February 26, 2004

RE: Yale Street Subdivision, Lots 2, 4, and 5

TITLE:
LOT 2
BUILDING LAYOUT
CWS ARCHITECTS
SCALE: 1"=20'
DATE: 8-4-03
JOB #: 4080

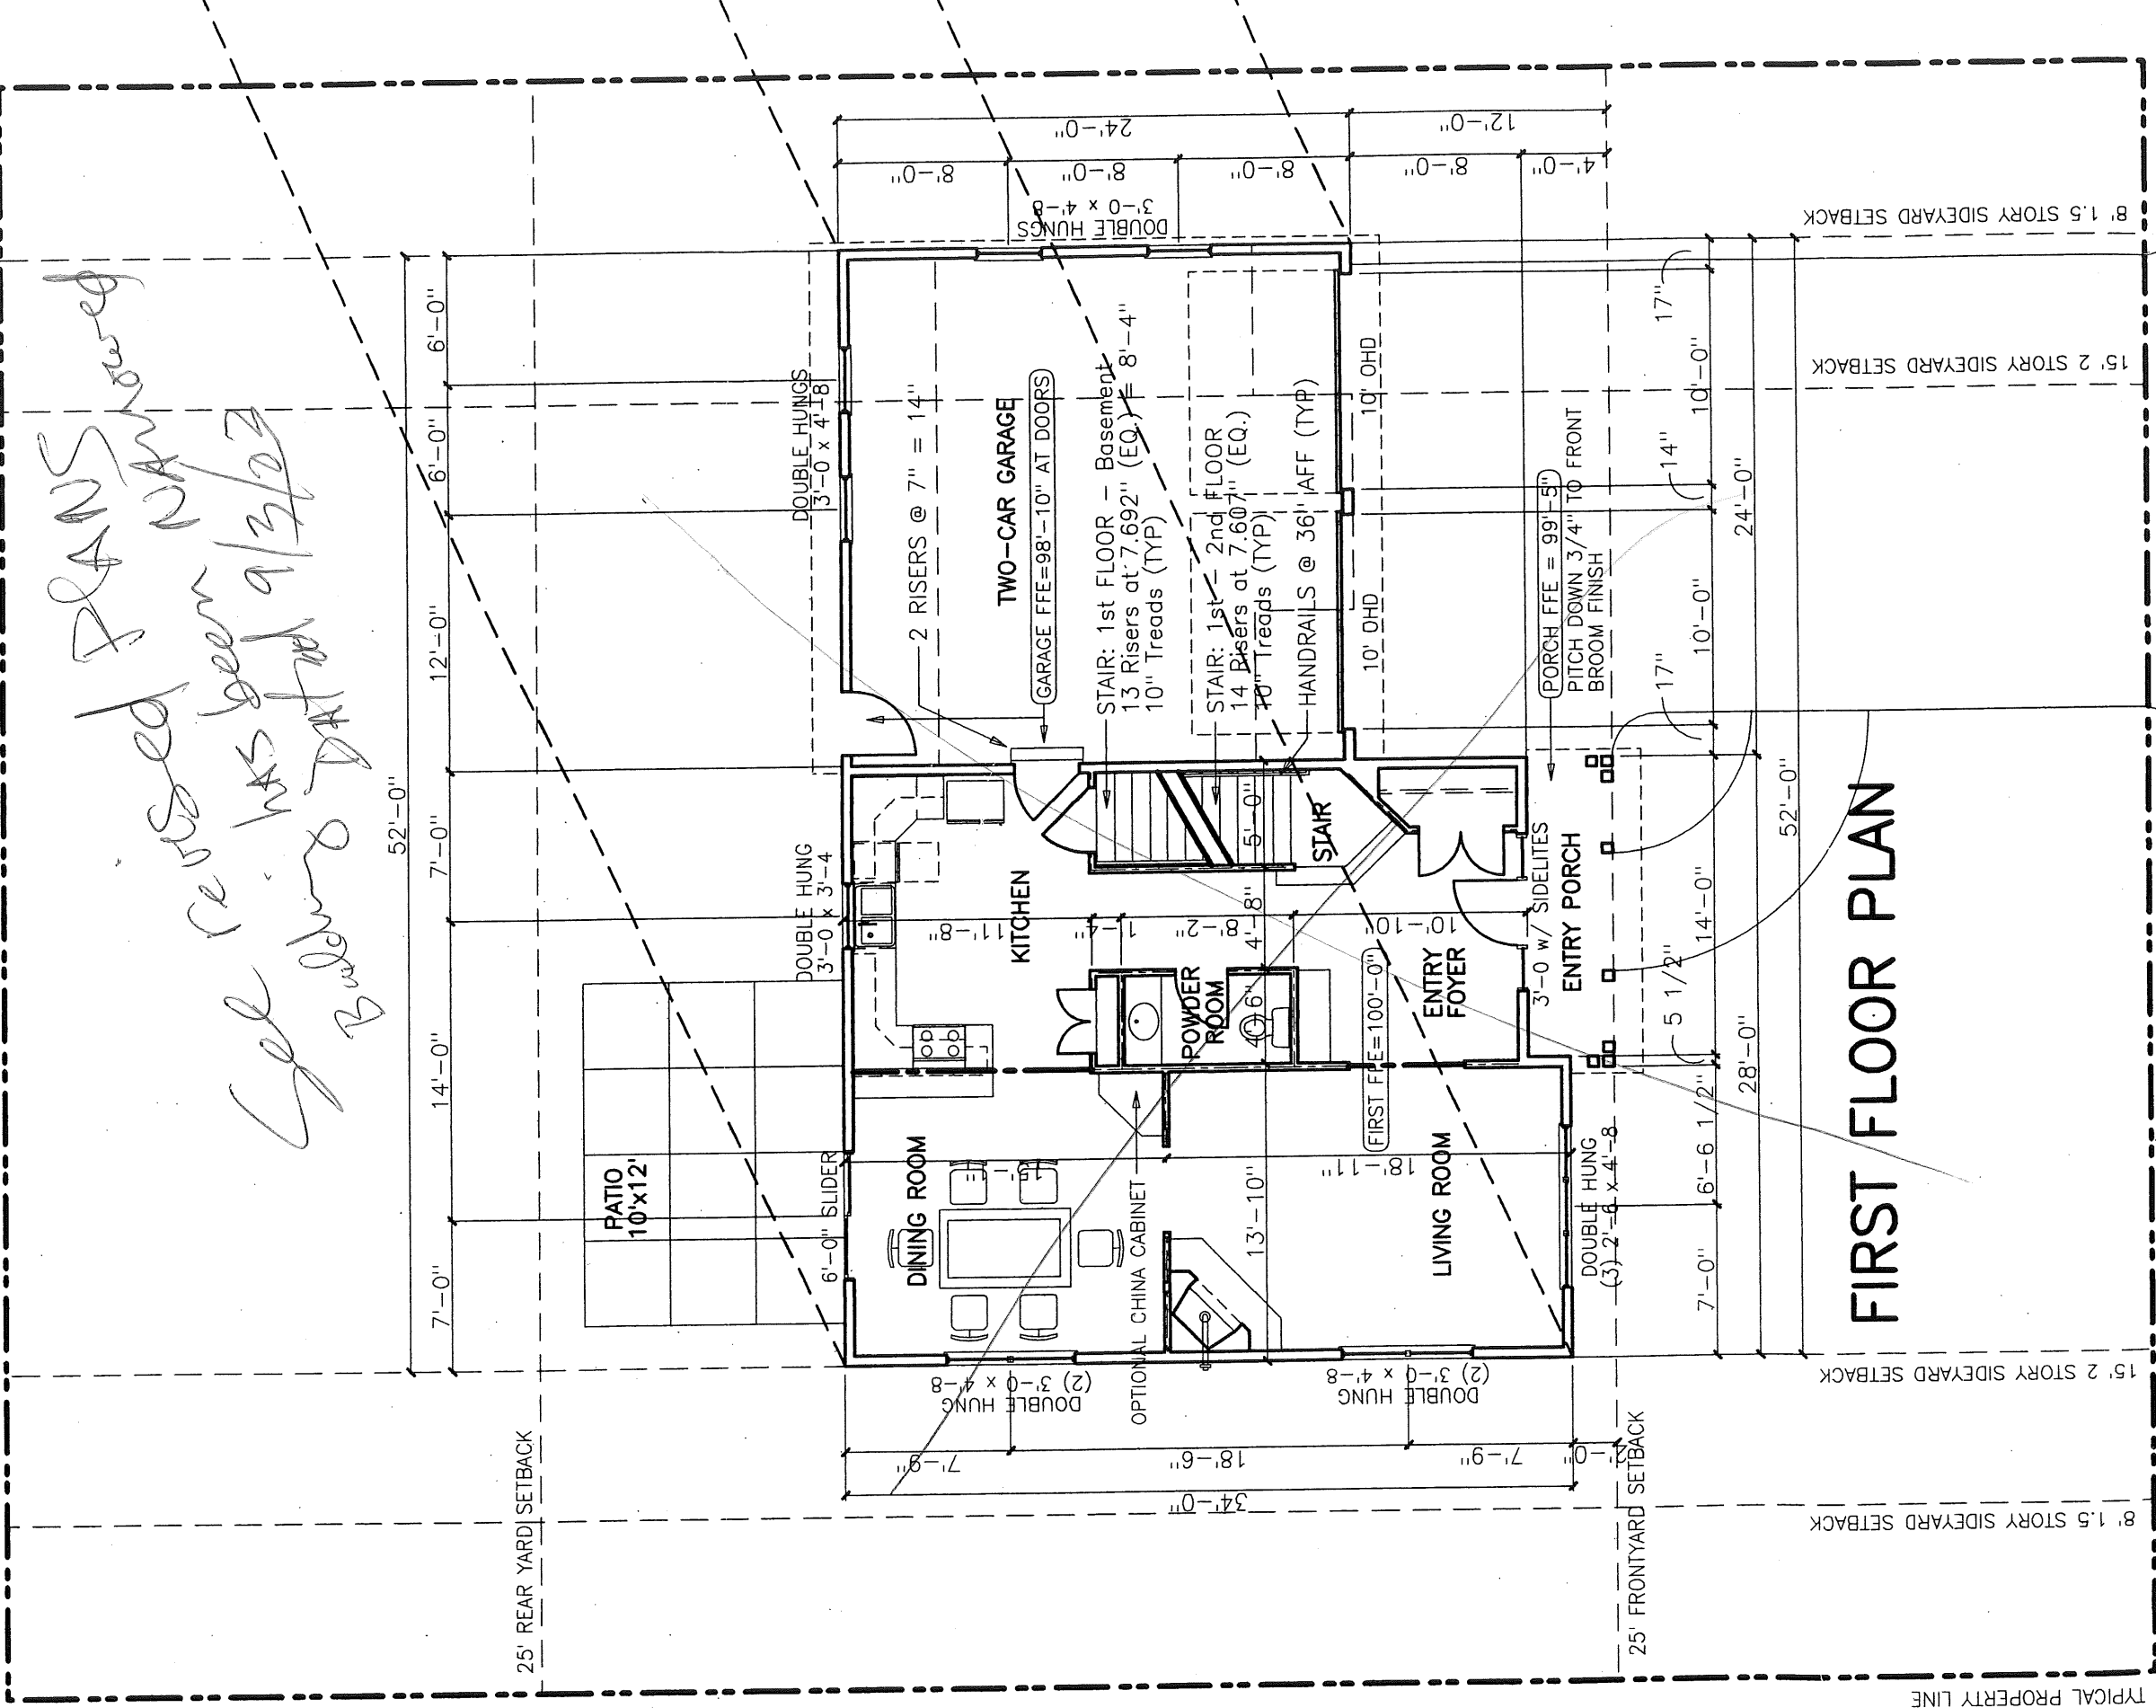
After meeting on site to look at the buildout of lots 2 and 5 of the Yale Street Subdivision, it was noticed that the buildout does not match the approved site plans. As discussed, the daylight basement features on lots 2 and 5 are not indicated on the site plan. As a result, the approved grading plans are not being constructed as proposed.

At this time, the City requests that you apply for a minor site plan amendment to the Yale Street Subdivision plan. In particular, this amendment should show new/proposed topography and a revision to sheet #9 (grading and drainage) is requested. Also, we had met previously to discuss the swale behind the lots and the effort to conserve some of the existing trees. Tree preservation may make it difficult, or perhaps impossible, to construct the swale. Please address this within your amendment.
